About the application

Application number: 2026/91657	
What is the application for?:	Variation of condition 2 (plans) on previous permission 2020/93954 for erection
Address of the site or building:	Land at Lingards Road, Slaithwaite, Huddersfield, HD7 5HY
Postcode:

Front elevation (1:100)

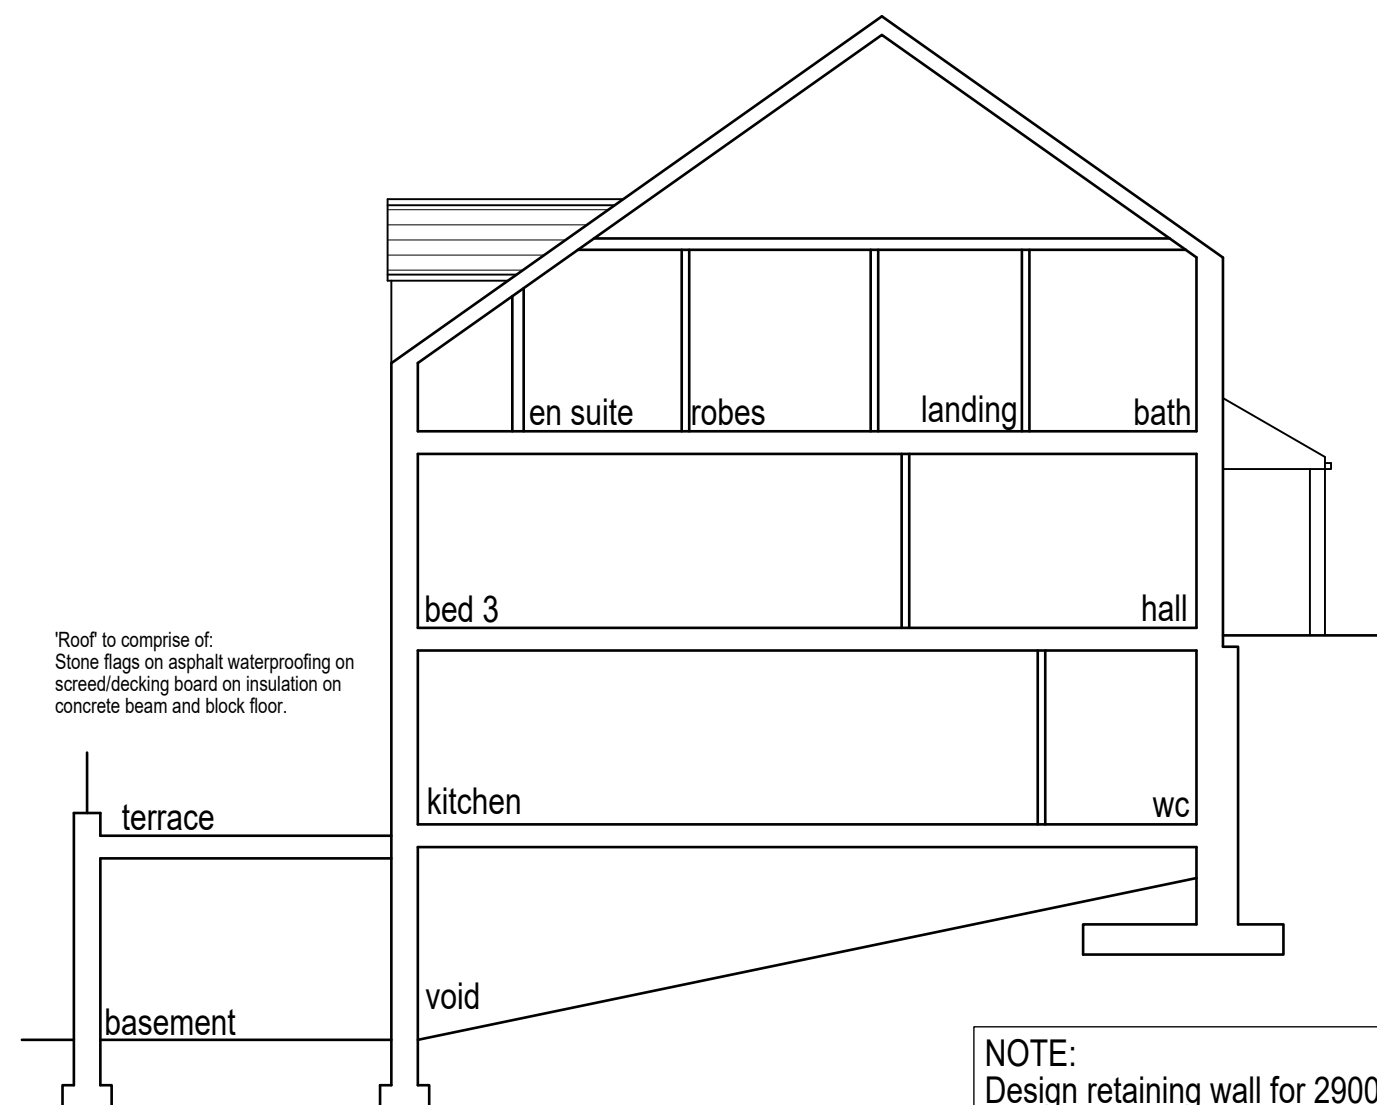
Type of comment: An objection	
Do you wish your comments to be published on the website anonymously?	Yes
This variation by the developer could and should of been submitted on the original application, thew developer has all ready built the foundations on the assumption that the variation will be approved and is avoiding the scrutiny of a full application and the design intent that was stated by the developer at the time application was approved.
